NSW RURAL FIRE SERVICE

Your reference: SSD 6917 MOD 4
Our reference: D17/2316

Notice of Section 96(1A) Modification to Oakdale South Industrial Estate – Concept Proposal and Stage 1 (SSD 6917 MOD 4).

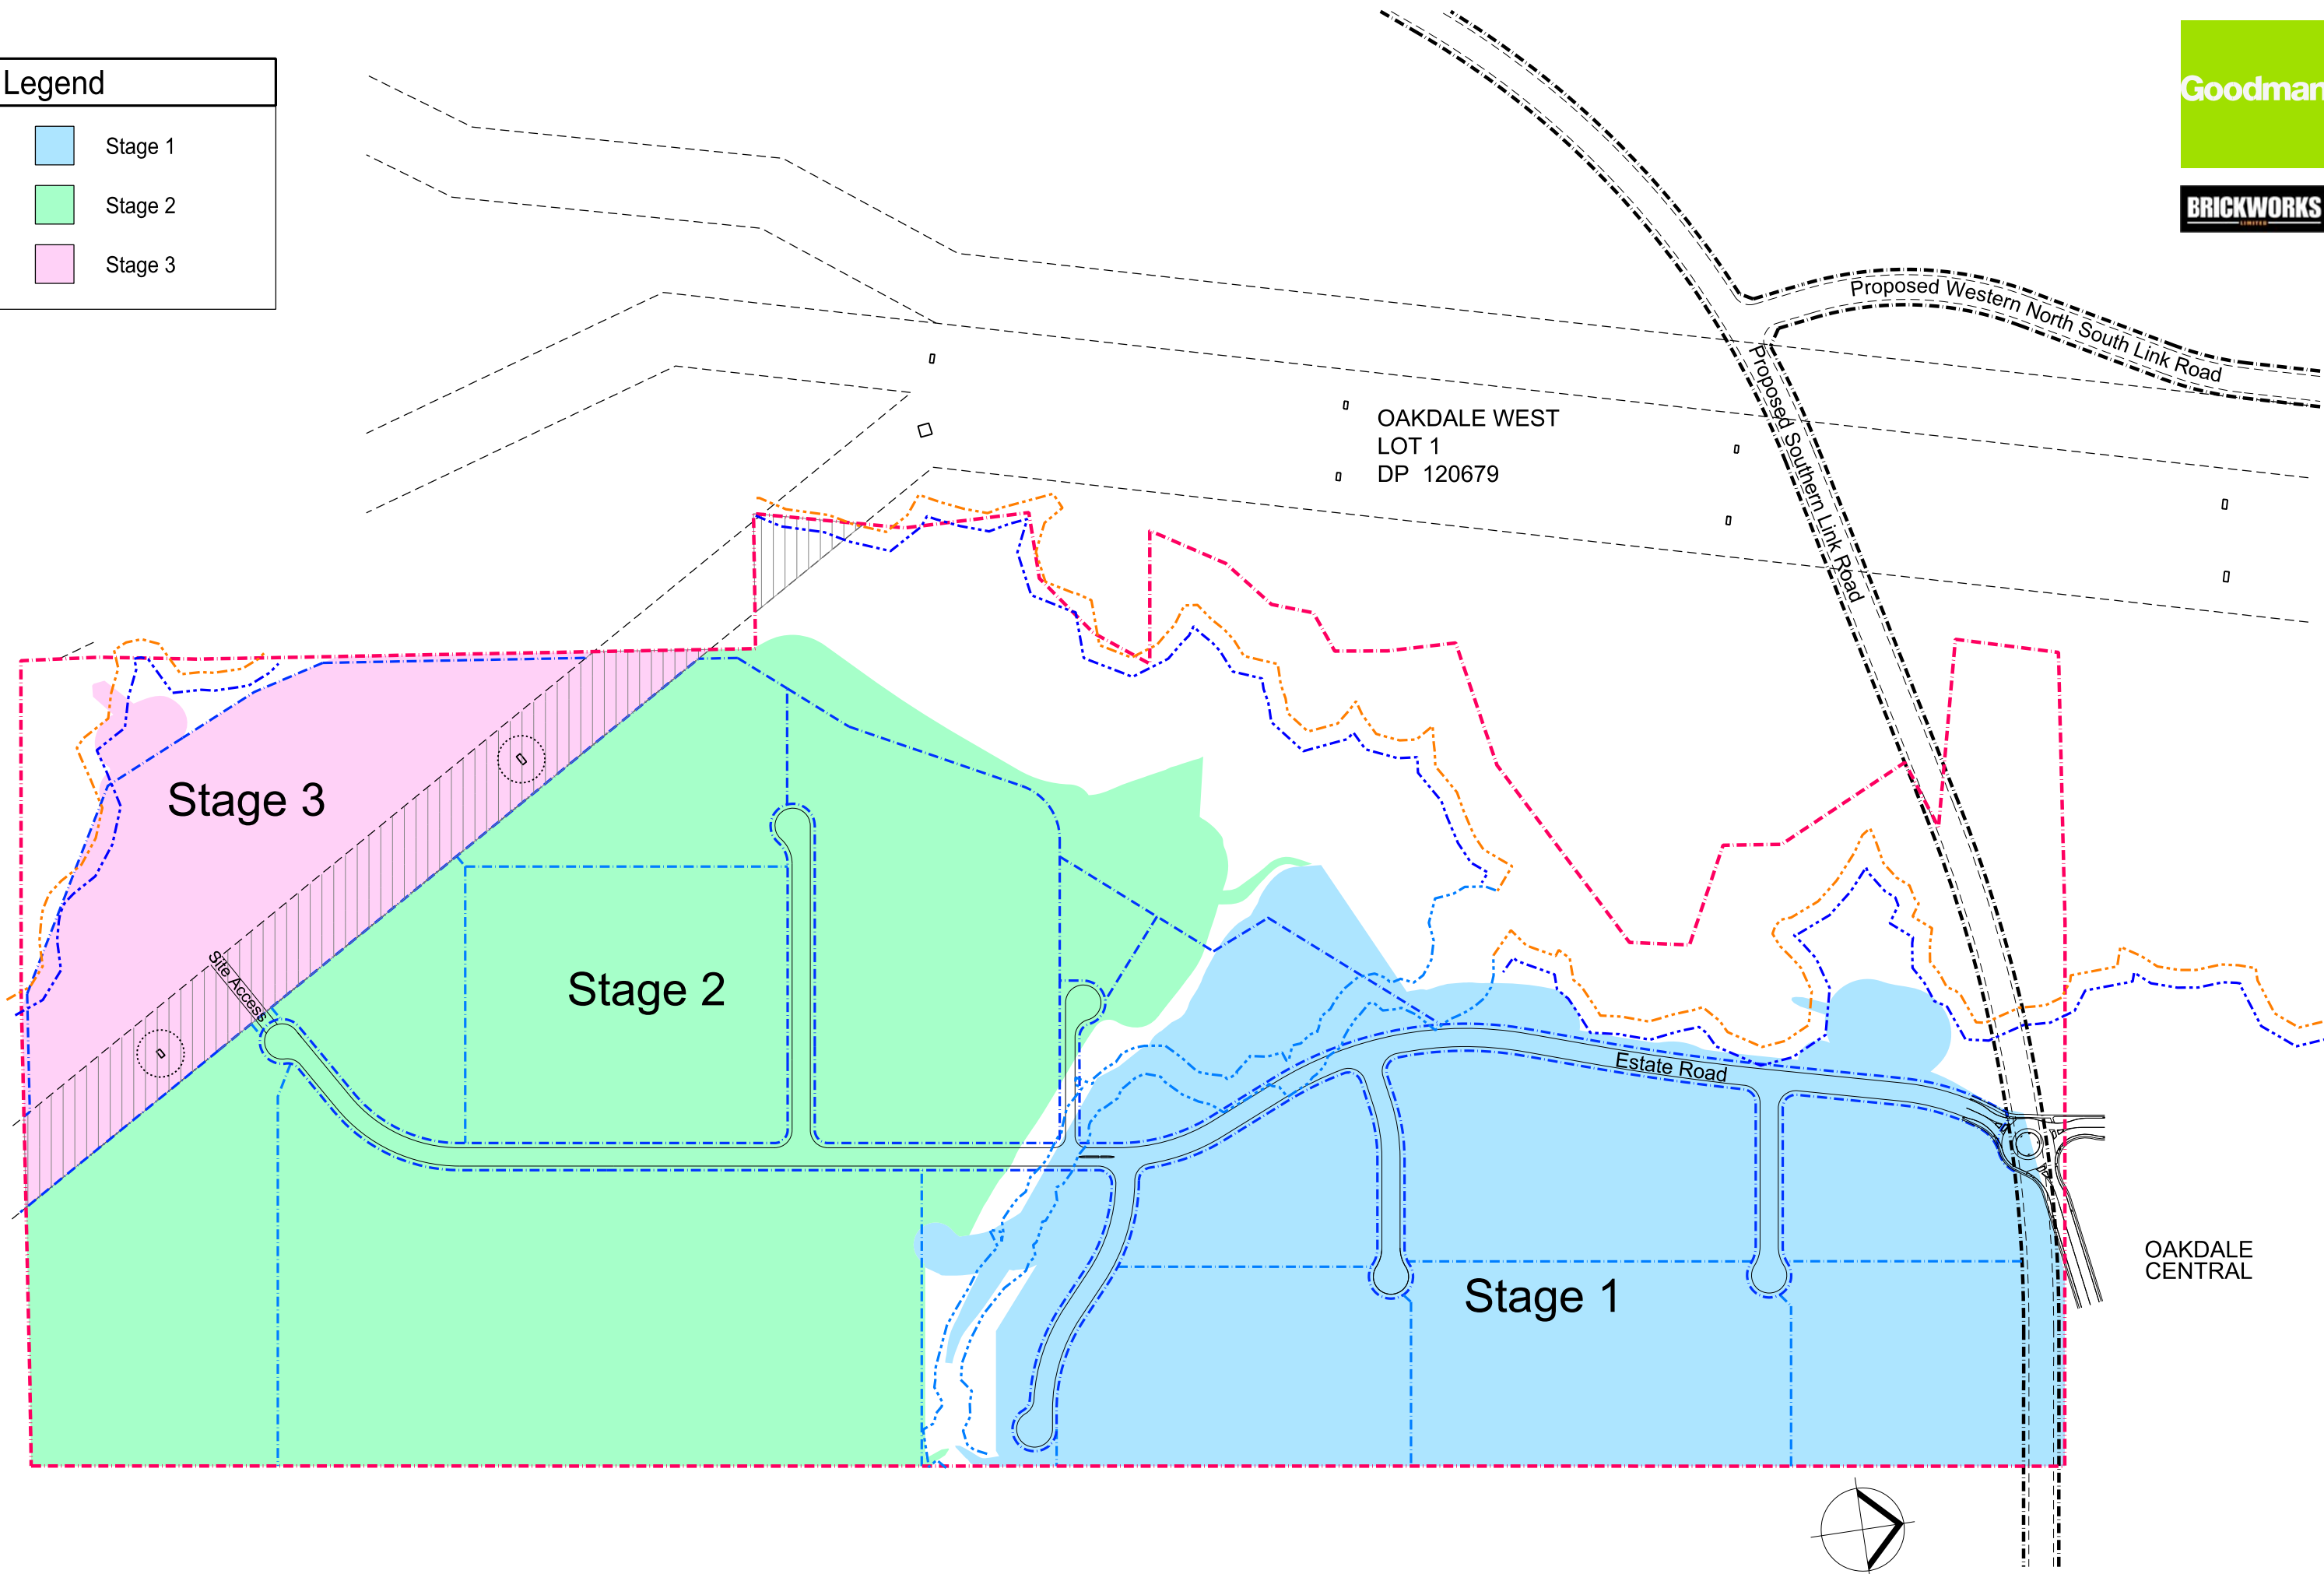
1. A 26 metre asset protection zone (APZ) is to be provided along the eastern boundary of Biodiversity Lot 1 and the northern boundaries of Biodiversity Lot 2 and Lot 3 and a 10 metre APZ is to be provided along the southern boundary of Biodiversity Lot 2 as shown on the plan titled '*Bushfire Protection Plan*' OAK MP 13 (N) prepared by SBA Architects dated 2 August 2017. APZs to be maintained in accordance in 'Planning for Bush Fire Protection 2006' and the NSW Rural Fire Service's document 'Standards for Asset Protection Zones'.
